**Re: Glassrite at 5605 Venice Ave NE
Erosion and Sediment Control Plan
Engineer's Stamp Date 4/11/23 (B18E026)**

Based upon the information provided in your submittal received 4/18/2023, the above-referenced ESC Plan cannot be approved until the following comments are addressed.

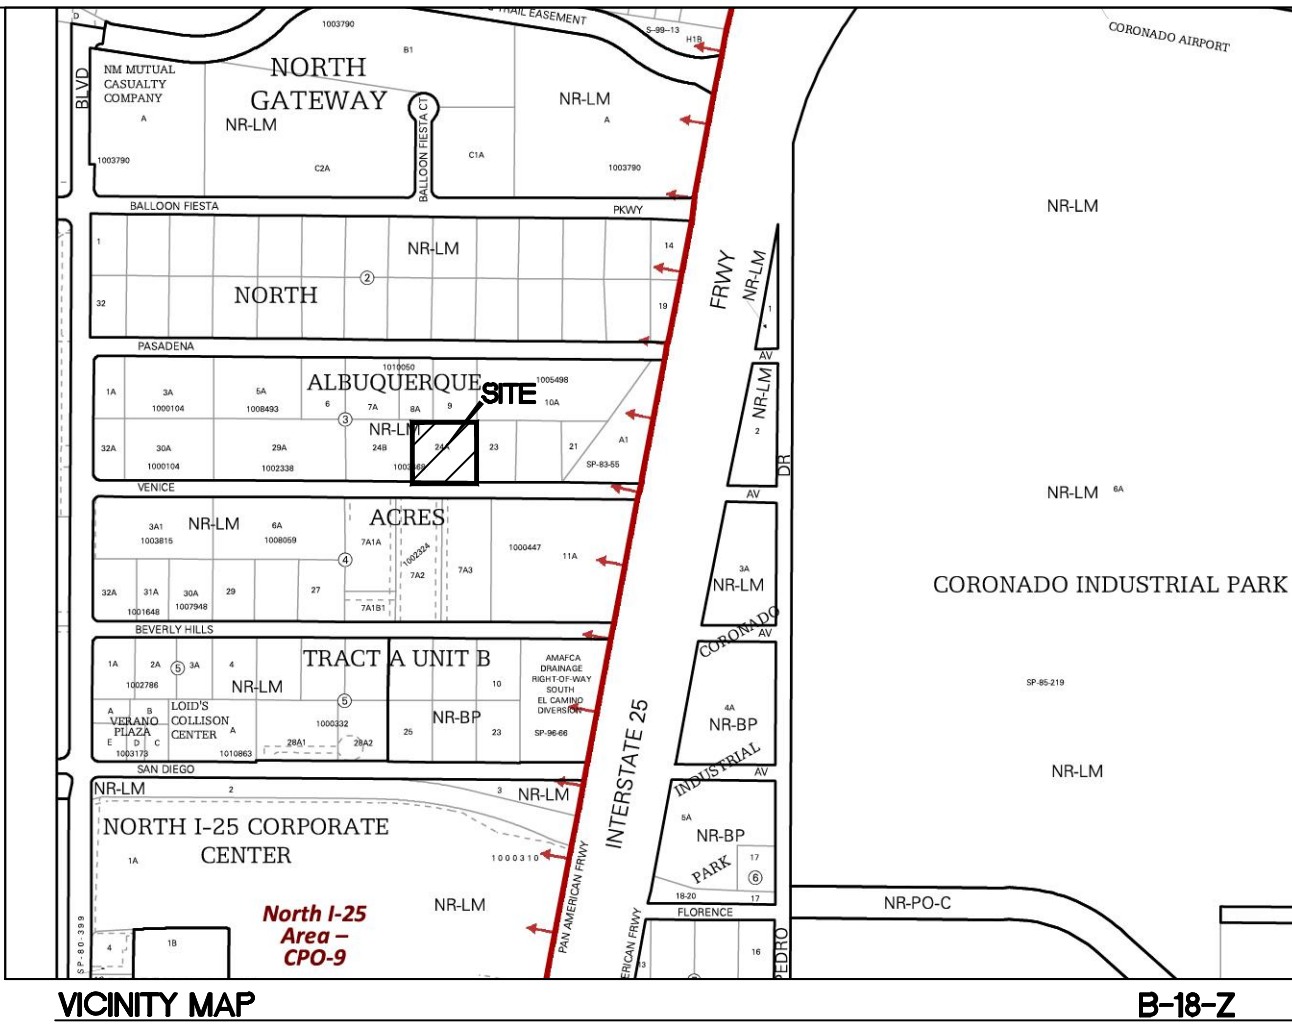
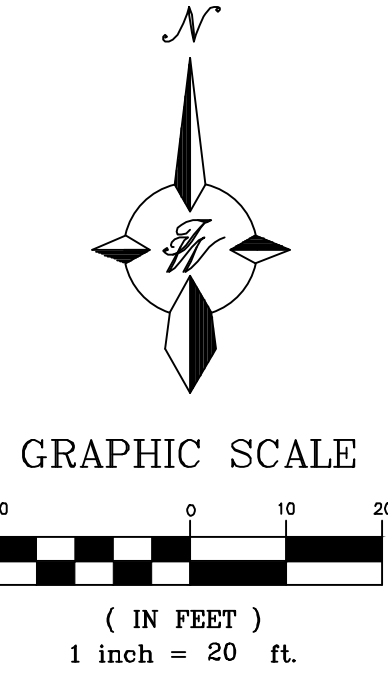
1. The ESC Plan can't be approved until after Hydrology approves the G&D Plan for each specific purpose, Site Plan, Grading, Building Permit, and Work Order. The only purpose Hydrology has approved so far is Site Plan. The existing and proposed grades must be shown on the ESC Plan, and they must agree with the Grading Plan approved by Hydrology (CGP7.2.4.b.ii);

2. There are a number of different hatch Patterns that are not identified in the legend on the ESC Plan. These structures must be clearly identified in the SWPPP per CGP 7.2.4.b.vi. The same information is required in the ESC Application. You may attach a copy of the Site Plan to both the SWPPP and the ESC Application to address this requirement or add a legend to the ESC Plan.

4. The SWPPP must include site-specific interim and permanent stabilization per CGP 9.4.1.c.i. The Landscape Plan can be used to satisfy this requirement and should be submitted separate from the ESC Plan with the application to the Stormwater Quality Section of the Planning Department and it should be included in the SWPPP. Provide a specification on the ESC Plan for any disturbed areas not covered by the Landscape Plan.
